Appeal Decision

Decision date: 29 May 2019

Appeal Ref: APP/R5510/W/19/3221140
128D & 130D Manor Way, Ruislip HA4 8HR

PROPOSED ELEVATIONS

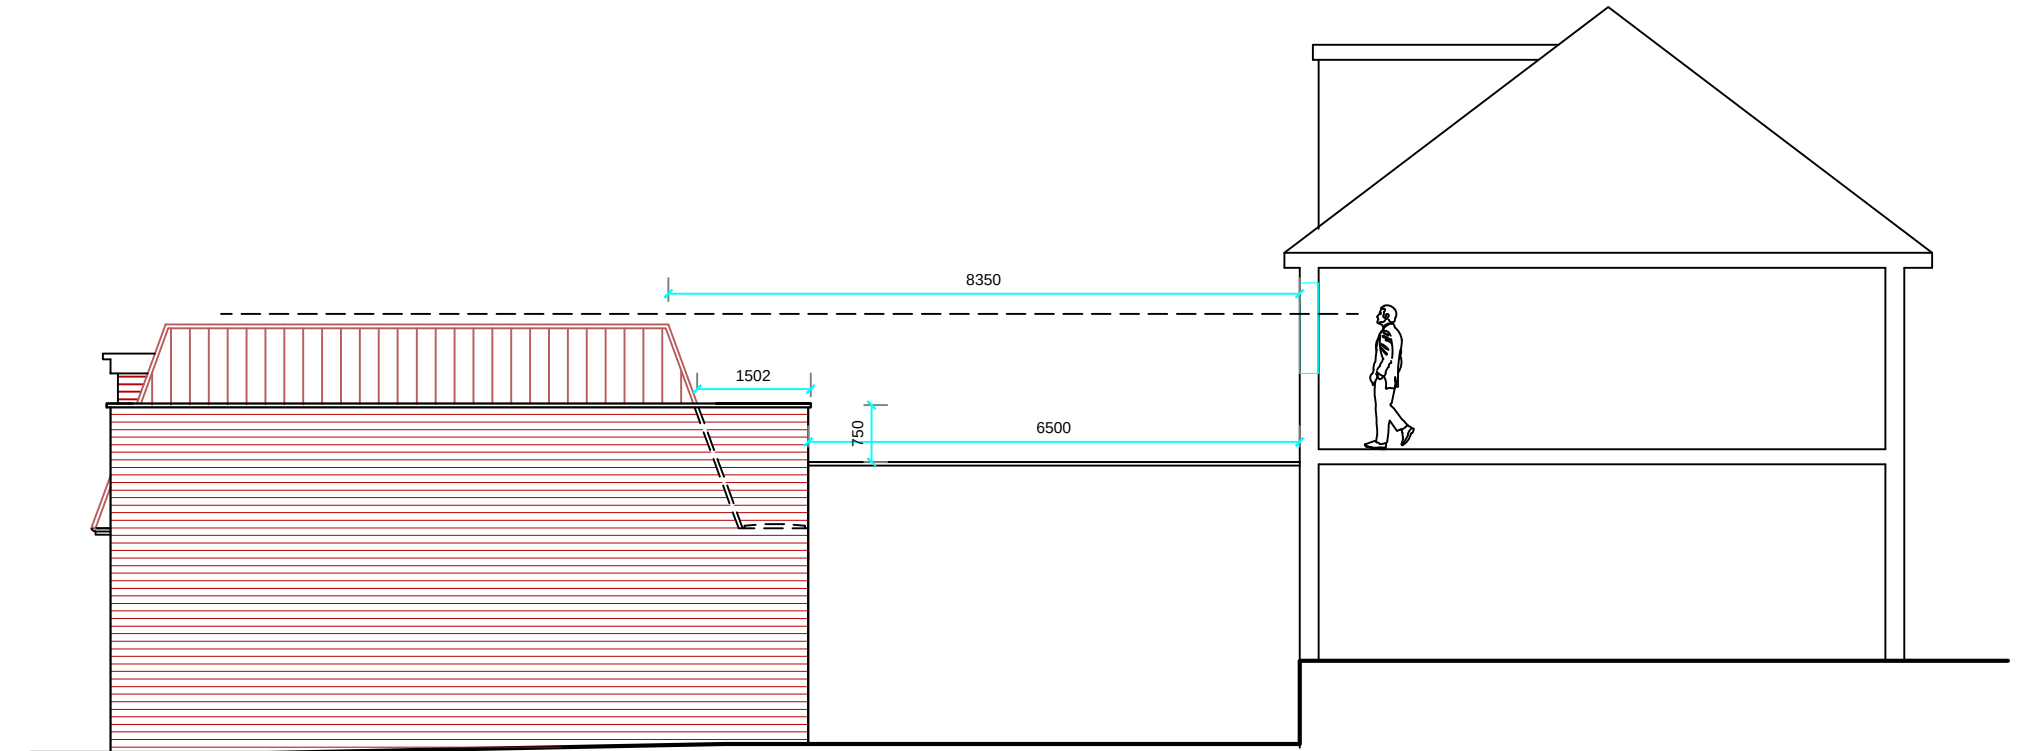
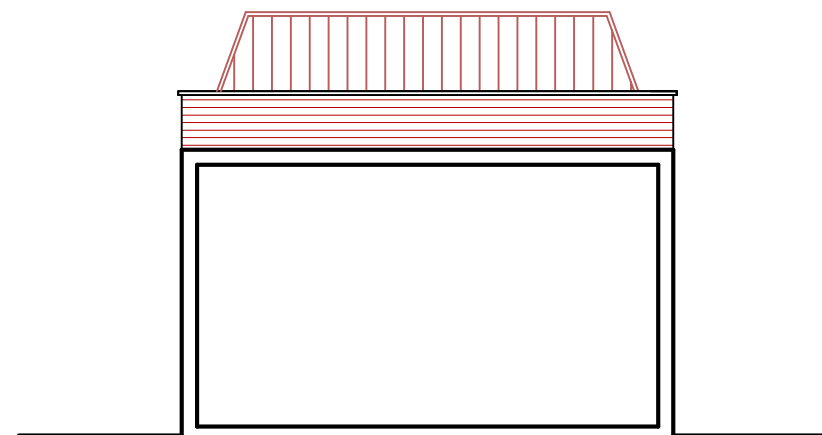
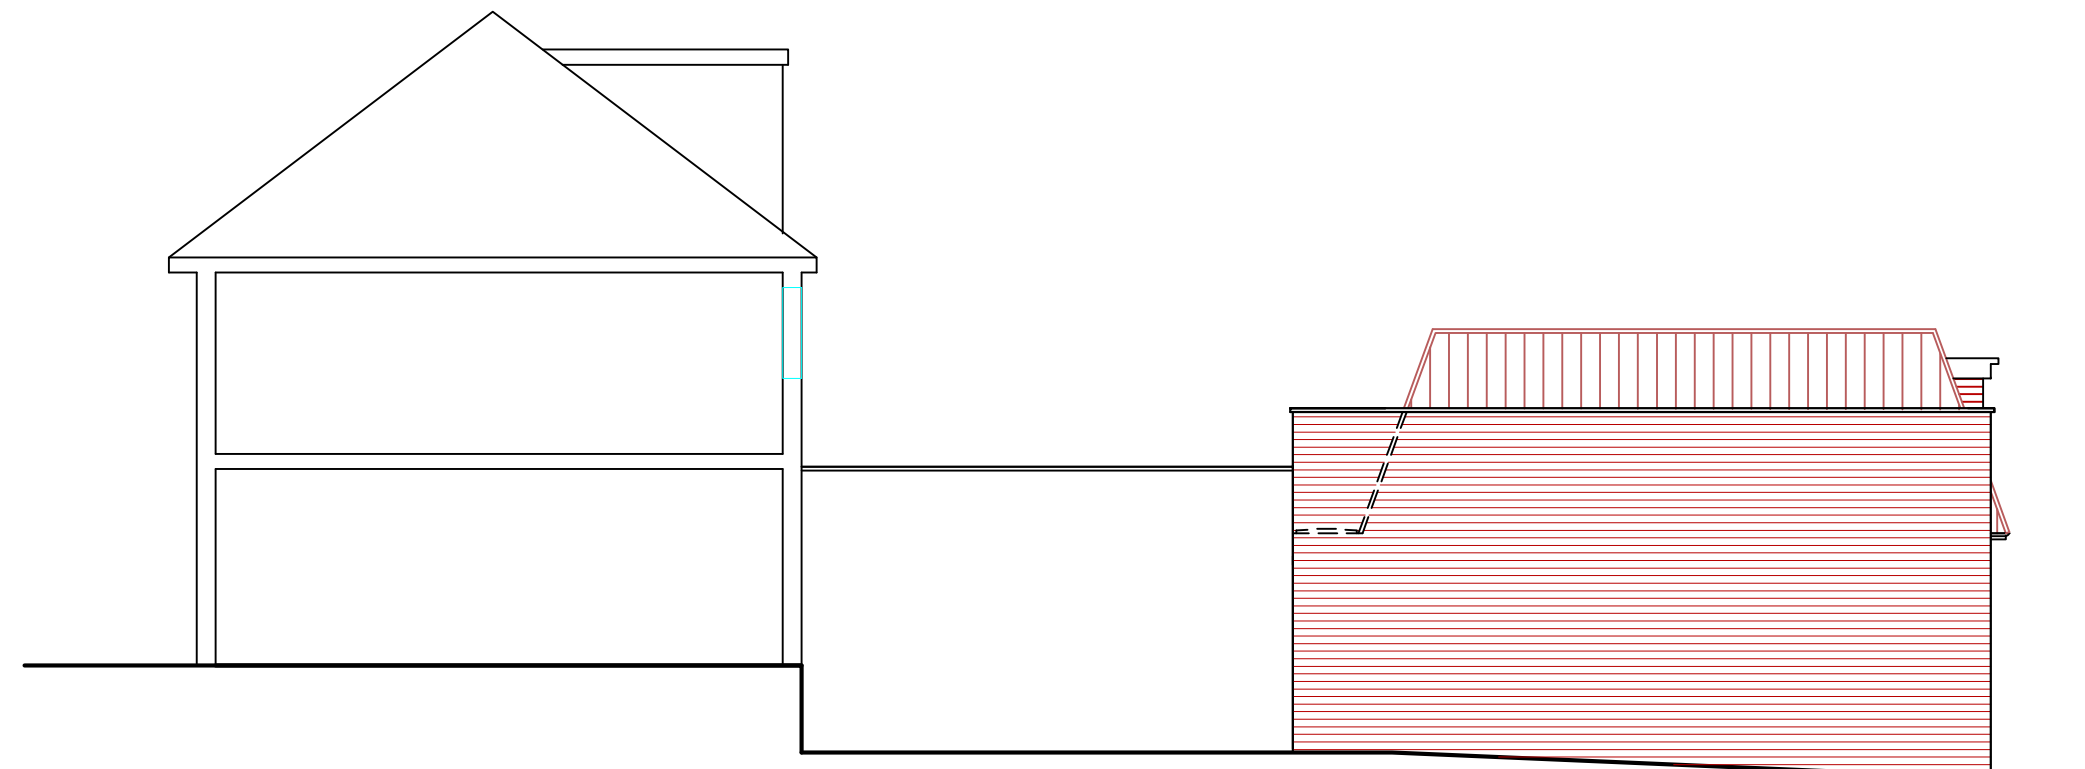
4. The depth of the existing flats would be increased by around two metres as a result of their conversion to studio flats. This would bring the front elevations closer to the properties' boundary and to the side wall of No 42 Windmill Hill, a large building, which is positioned directly behind Nos 128 and 130 on the other side of the driveway.

5. At present the two flats each have a window facing No 42 serving a bedroom and a window to the side elevation serving the kitchen and living room. In the proposed development, each of the four studio flats would have only one window in what would be the front elevation, facing No 42. I accept that due to the orientation of the properties and the provision of a skylight for the ground floor flats, the available natural light would be sufficient for acceptable living conditions.
-

6. However, the only available outlook from each of the flats, beyond limited views of the sky through the skylight, would be from the single window. For the ground floor Flat 2, the view from the window would be of the boundary wall of the appeal property and beyond this at close proximity the unrelieved, extensive side wall of No 42 Windmill Hill. The proximity and extent of views of the wall would result in it being a dominant and overbearing feature, which would materially harm the quality of the outlook from the rear window. The upper floor Flat 4 would benefit to a degree from the articulation to the upper rear of No 42, but the views from this flat would also largely be of the side elevation. For Flats 1 and 3, the view would be somewhat more open due to the position of the windows facing beyond the rear building line of No 42.

8. Therefore, for the above reasons, I conclude that the proposed development would not provide adequate living conditions for future occupiers of Flats 2 and 4, with regard to outlook. Consequently, it is contrary to Policy BE21 of the Council's Local Plan Part Two, which requires development not to result in a significant loss of residential amenity. The proposal would, however, provide adequate living conditions with regard to natural light and there is no conflict with development plan policies in this regard.
